Crow Trees Farm, Crow Trees Brow, Chatburn, BB7 4AA
LPA ref - 3/2022/0966

Further to our meeting in February and your comments of April, the applicants and design team have undertaken a full review of the proposals and we hereby submit revised plans as follows:

Drawing file: planx_downloads / 22_0966_Proposed_Plan_Dutch_Barn_Conversion.pdf

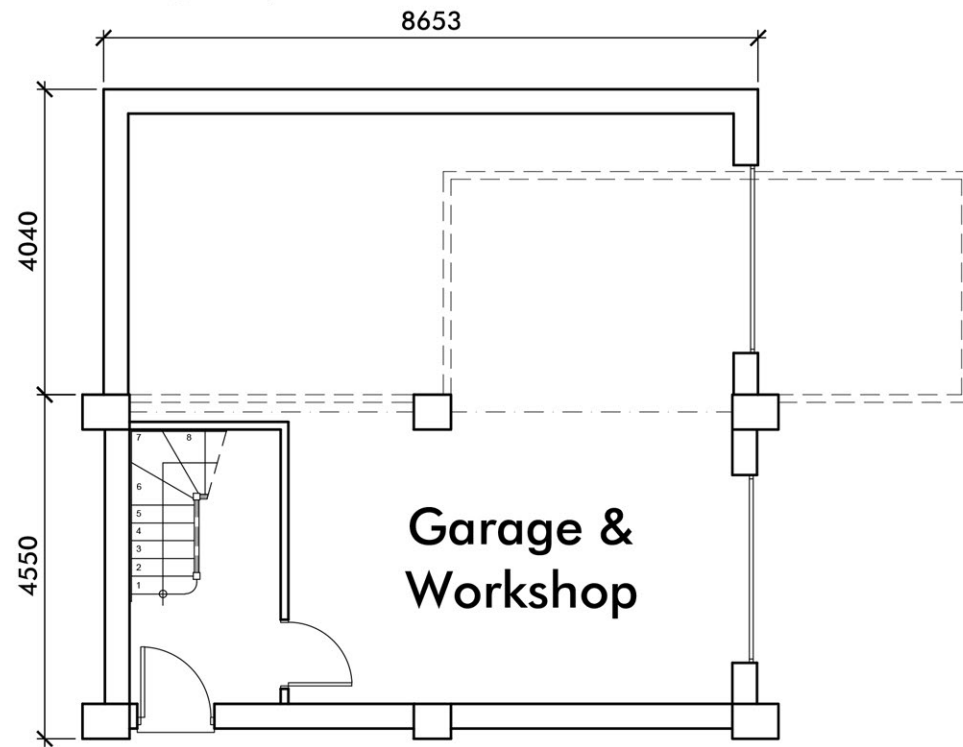
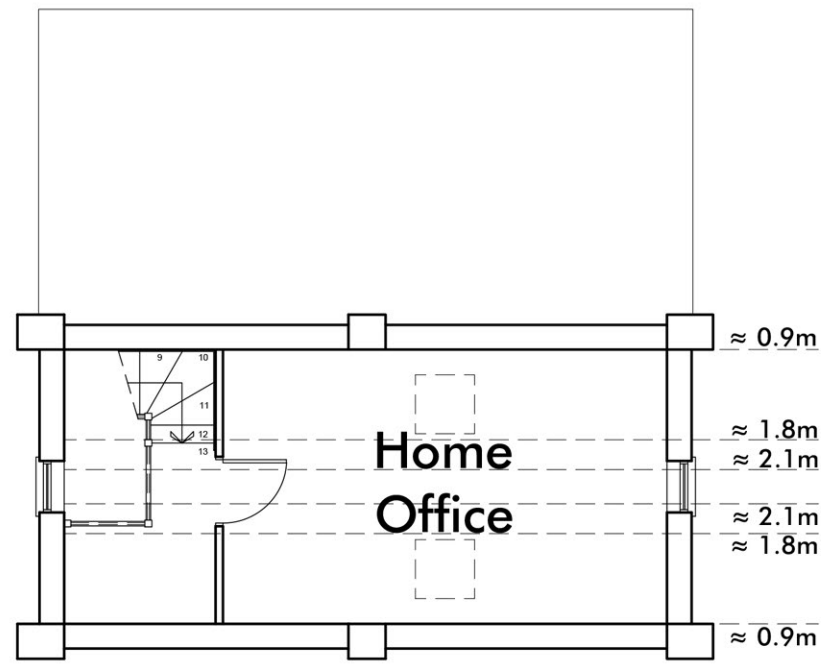
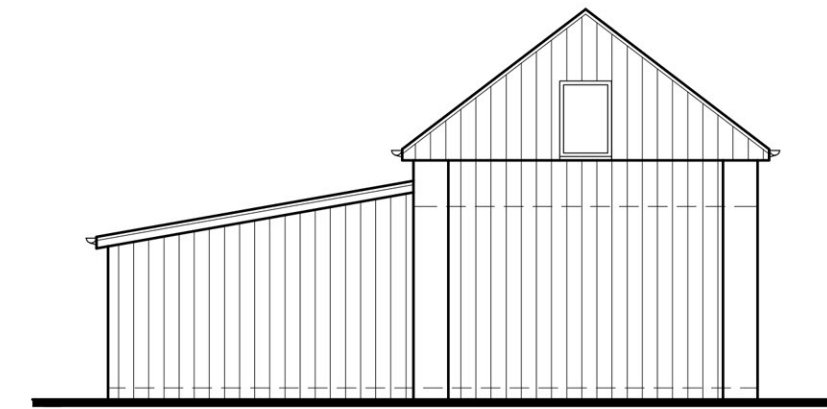
The scheme now proposes to utilise the dutch barn as such accommodation to provide a bedroom, en-suite and lounge/break-out space as well as a mezzanine study (that could be used by guests or the occupants). The size, design and materials of the building remains as previously proposed with the exception of additional windows to the side and rear elevation. As this building is a newer feature on the site (and not listed), there should be no undue considerations from its reuse.

Drawing file: planx_downloads / 22_0966_Proposed_Site_Layout_16Jun23.pdf

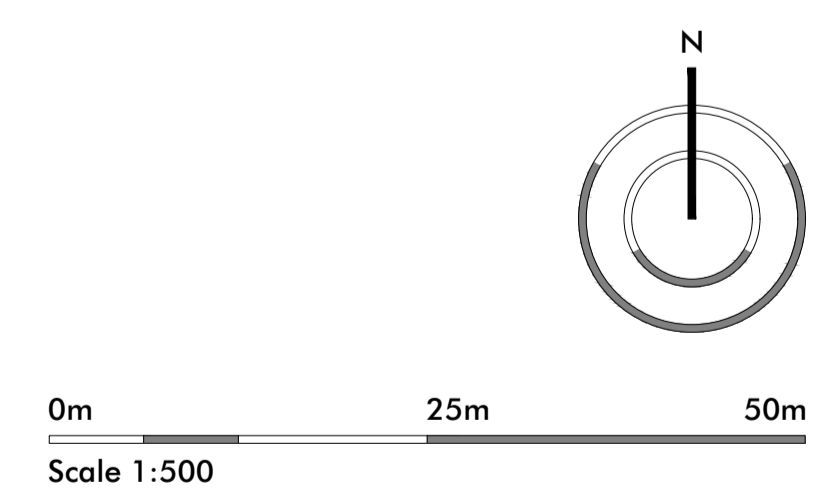
- Two bungalows have been moved to the south-west corner replacing the 4 unit mews block and the units on plots 19-22 have been re-positioned so introducing design and height variation, a reduction of 2 units and a less linear approach to development in this part of the site
- Repositioning of the units on plots 11/12 to turn the corner and the offsetting of units on plots 13/14 to provide more variation in street scene views and a less linear frontage relationship when moving along the access road through the site
- The alteration of unit types and positions has also enabled parking to be adjusted via the use of side drives and removal of frontage parking so reducing its visual impact on the street scene

- Re-siting of 3 bungalows and the provision of 2 semi-detached houses (in place of the relocated bungalows) and the provision of side drives to the units enables the removal of the parking court and the units to be pulled further away from the farmhouse to provide for a wider open space buffer. This also enables more space between units (via the driveways) allowing views through to the gardens and landscaped boundary beyond, as well as retaining views across the front and rear of the units to and from the farmhouse and the edge of the Conservation Area.
